Barlings Beach Modification 6 – PPG response to submissions

drawn: GC scale: 1:2500 @ A3 date: 25.02.11 drawing no: MA-01 rev G

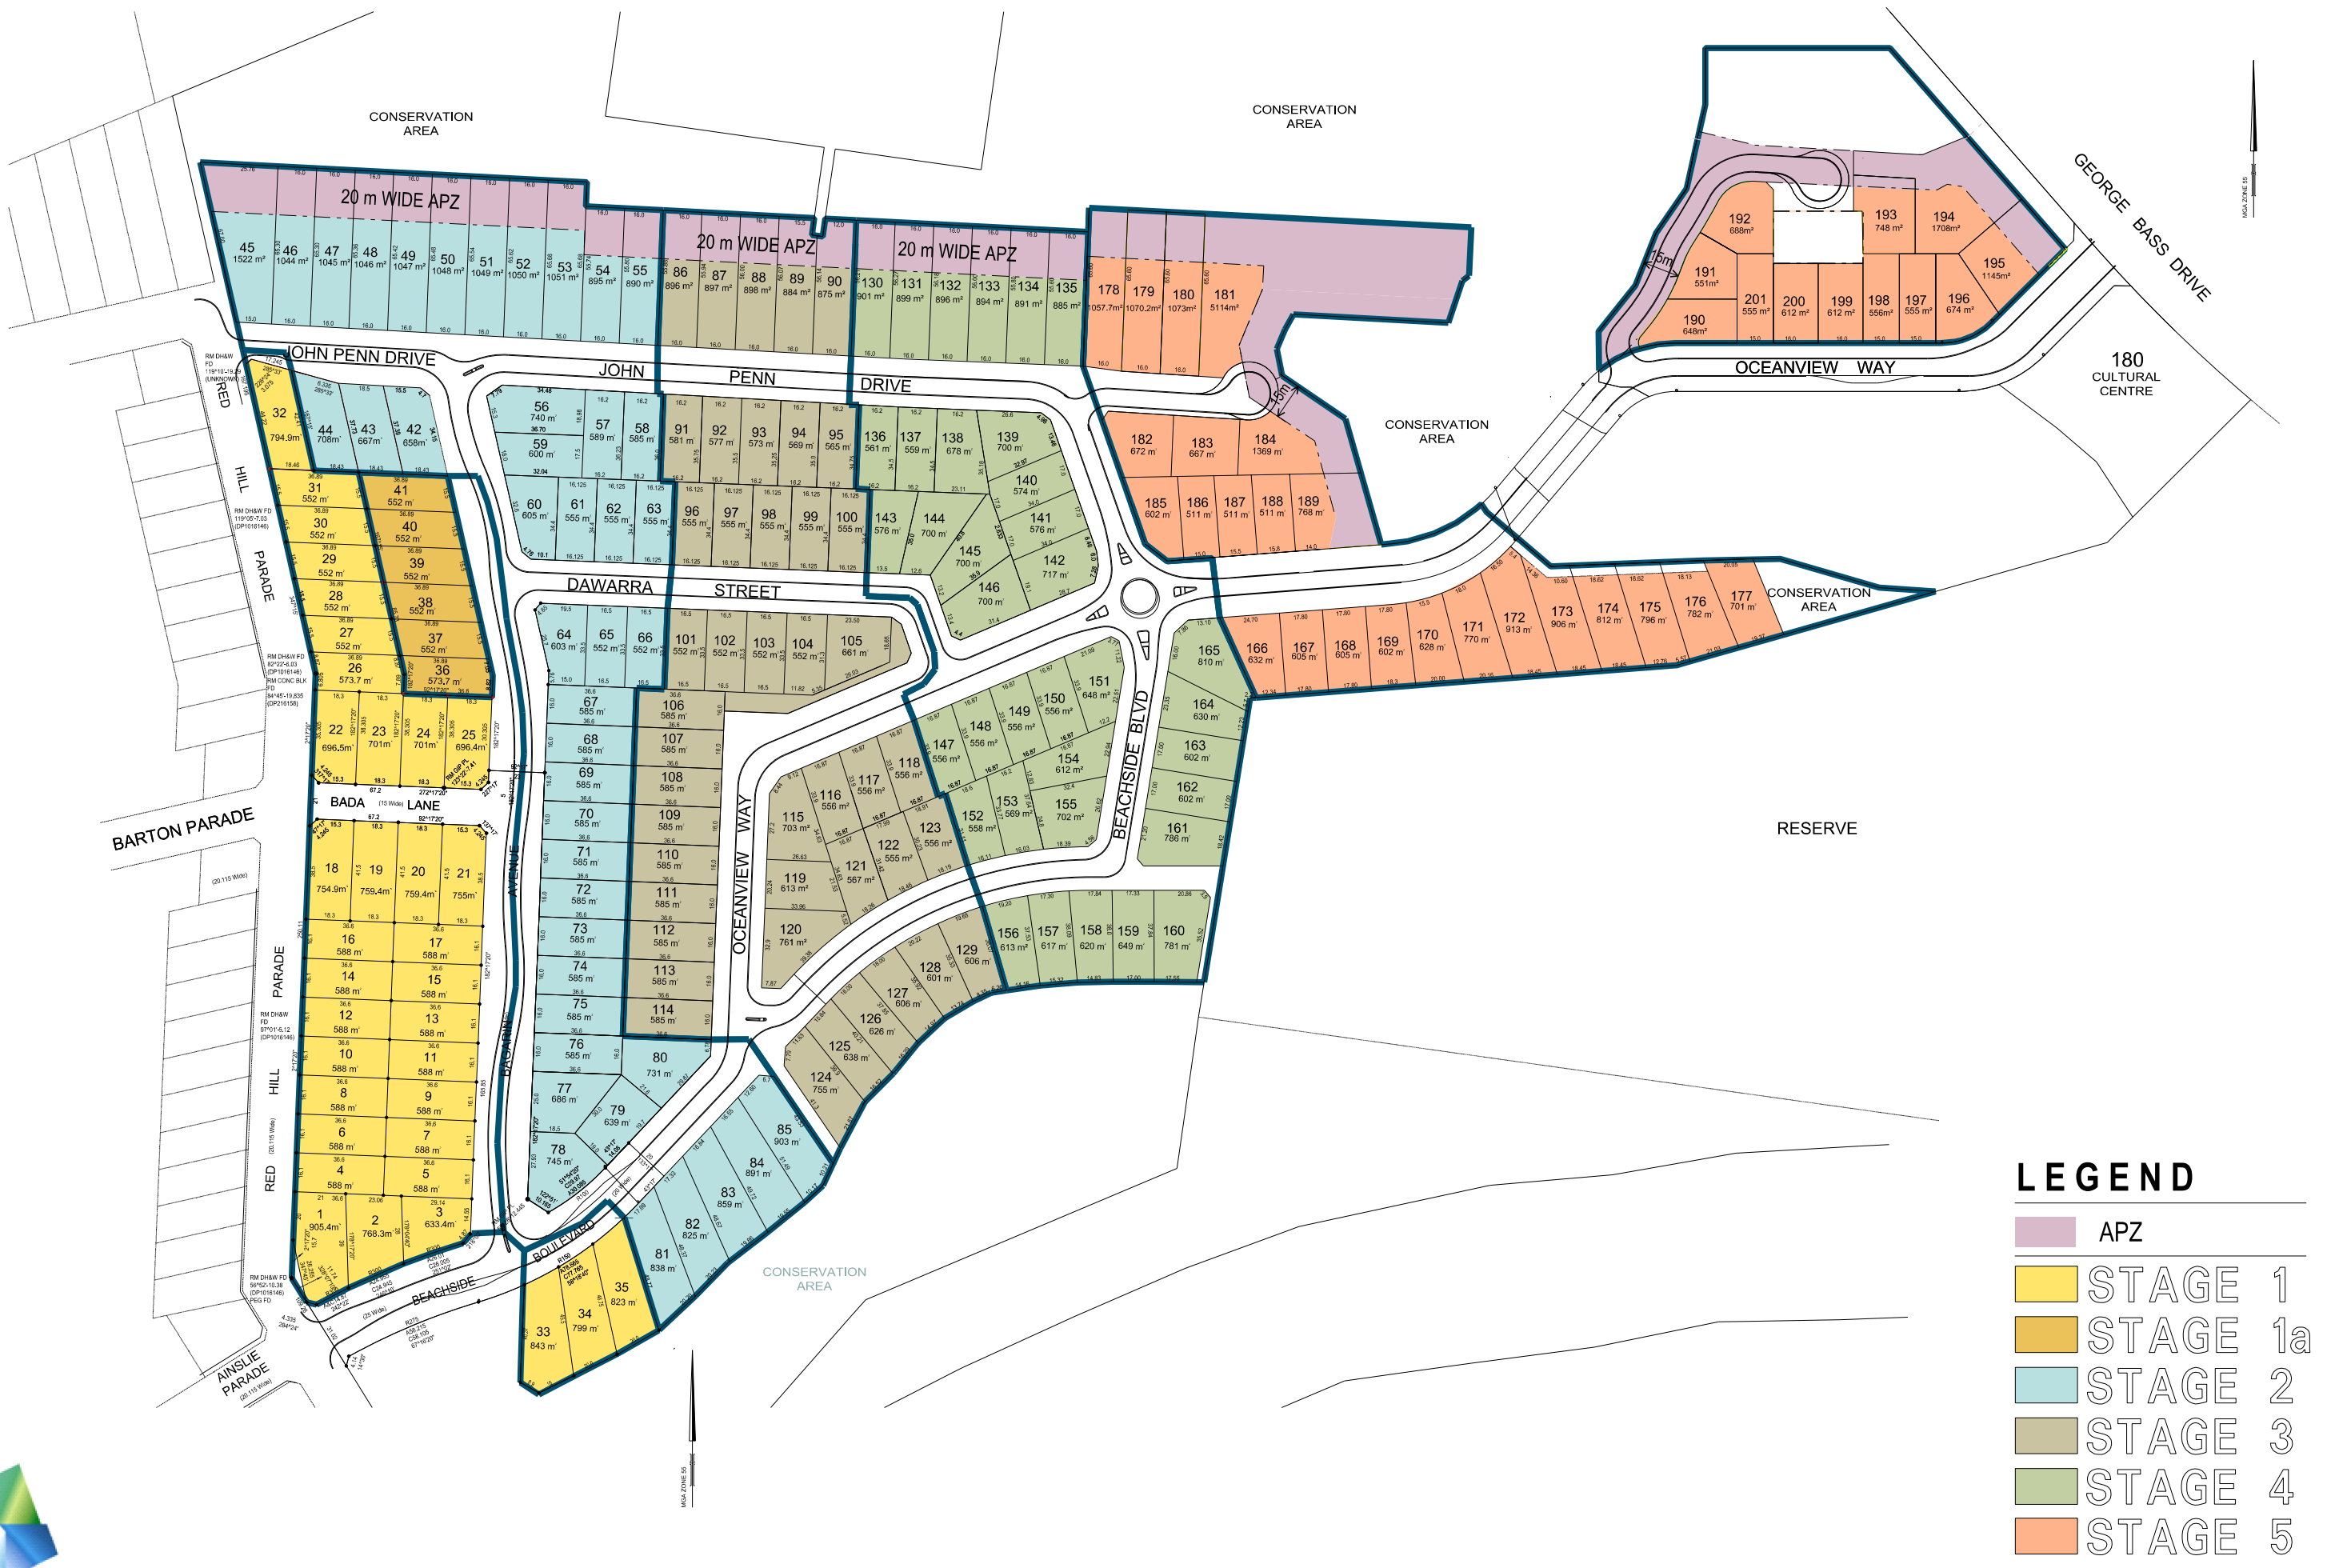
2.0 Department of Environment and Climate Change	
2.1 No objection provided some form of public access is retained to the Conservation Area surrounded by the proposed lot numbers 190 to 201.	Public access will be improved into the Conservation Area surrounded by proposed lot numbers 190 to 201. Public access is unrestricted from the road reserve at the northern boundary of the Conservation Area for its full width.

BARLINGS BEACH
STAGE 5A
FUNCTIONAL PLAN
LOT LAYOUT
 BARLINGS BEACH COMMUNITY PTY. LTD
 EUROBODALLA SHIRE COUNCIL
 Rev **C**
 Drg No **142468G01-1**

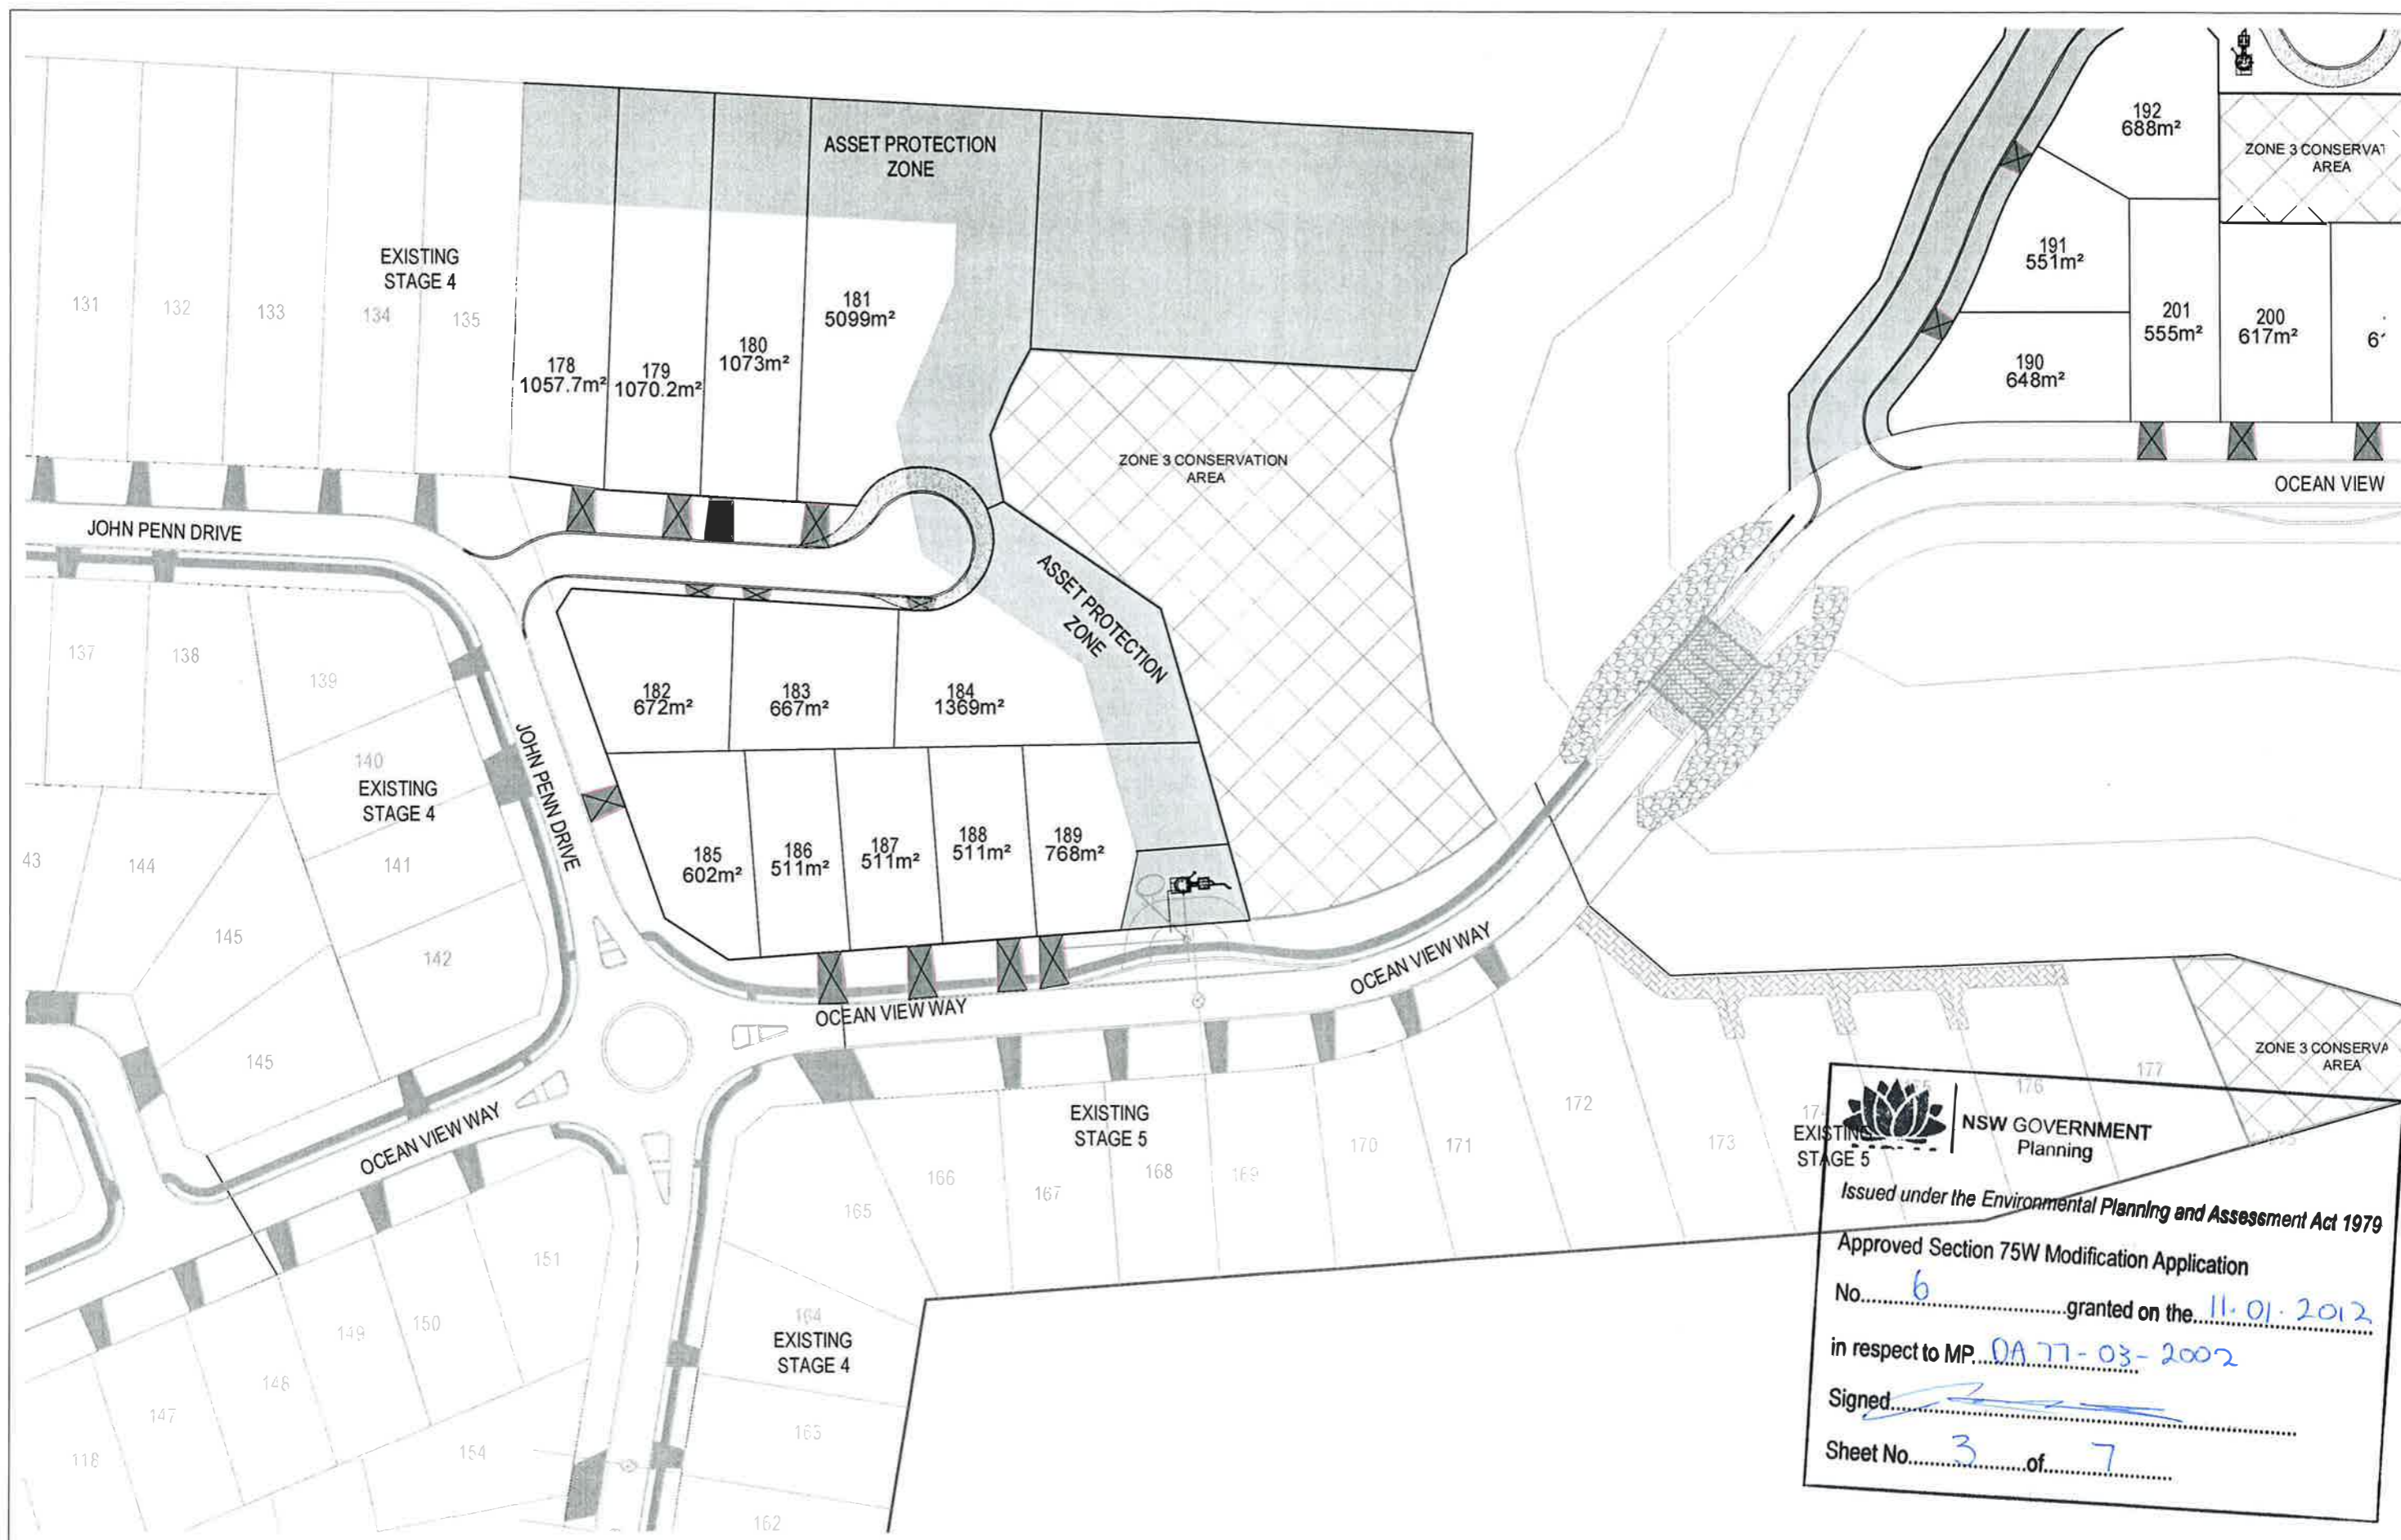
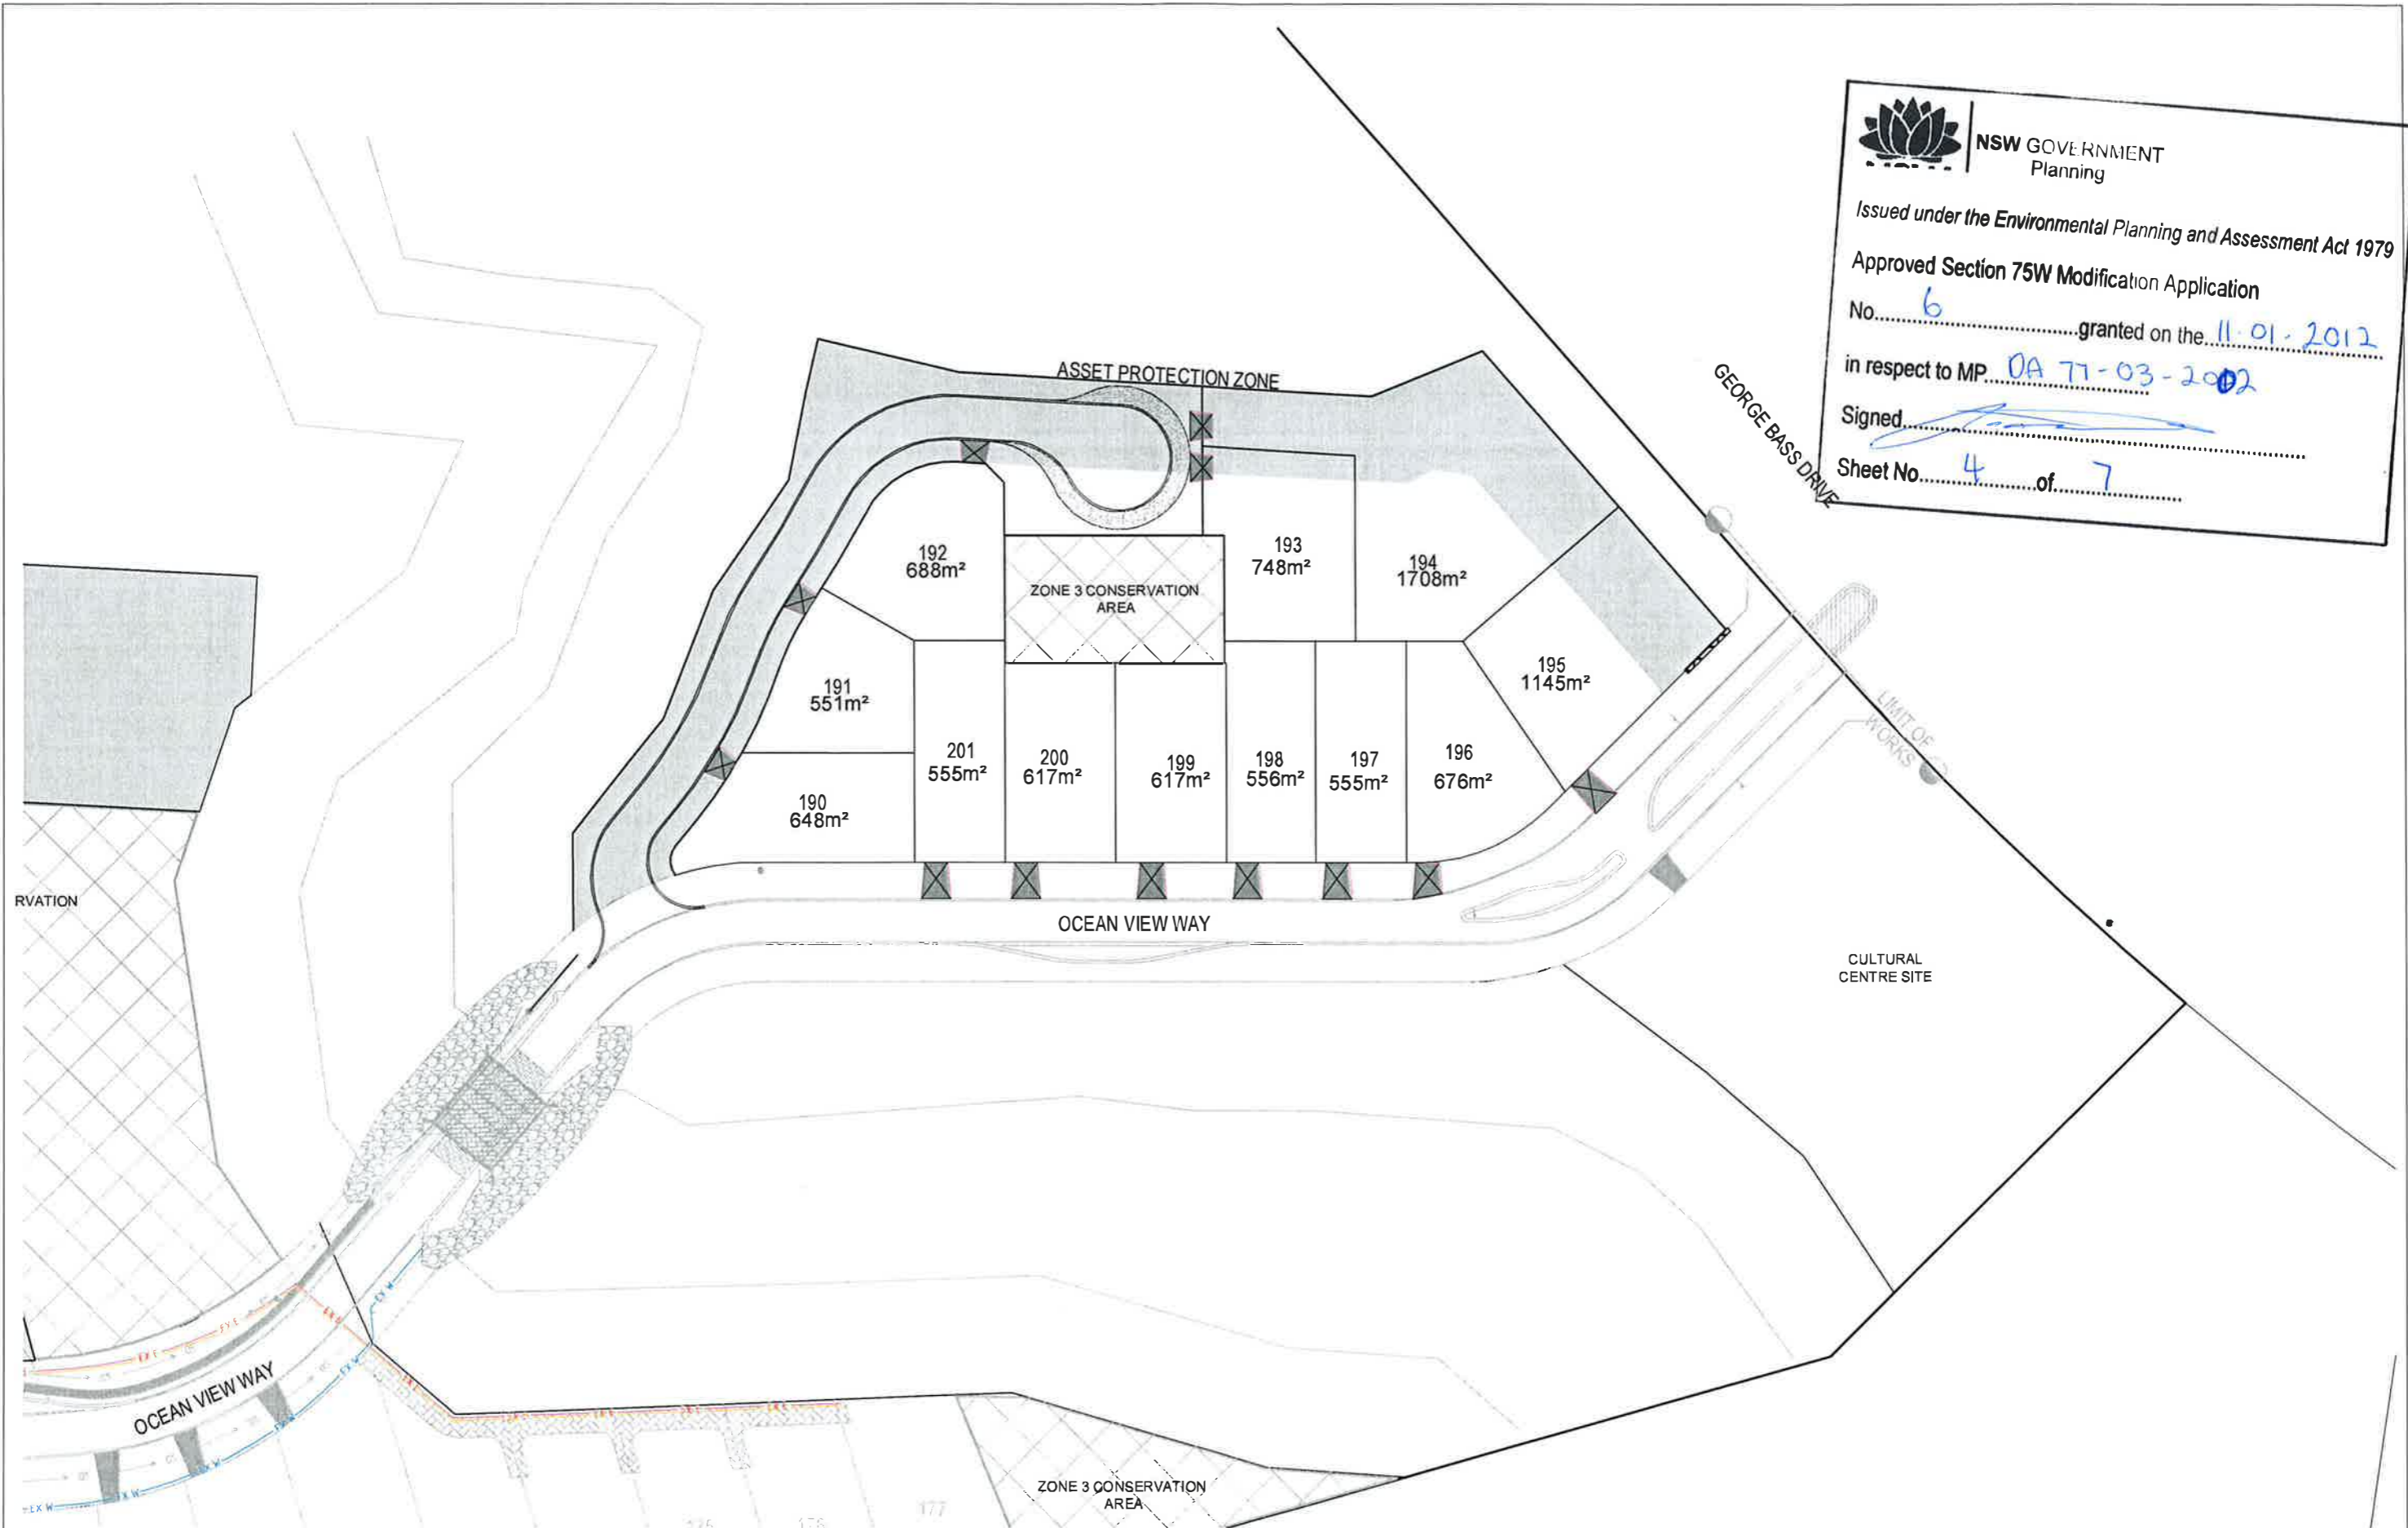
1.5 It is requested the cul-de-sac heads be constructed to full pavement standard (pavement design plus asphaltic concrete top course) and satisfy RFS requirements for 12.5m turning radius.	Noted. The turning circles have been designed to satisfy RFS requirements.
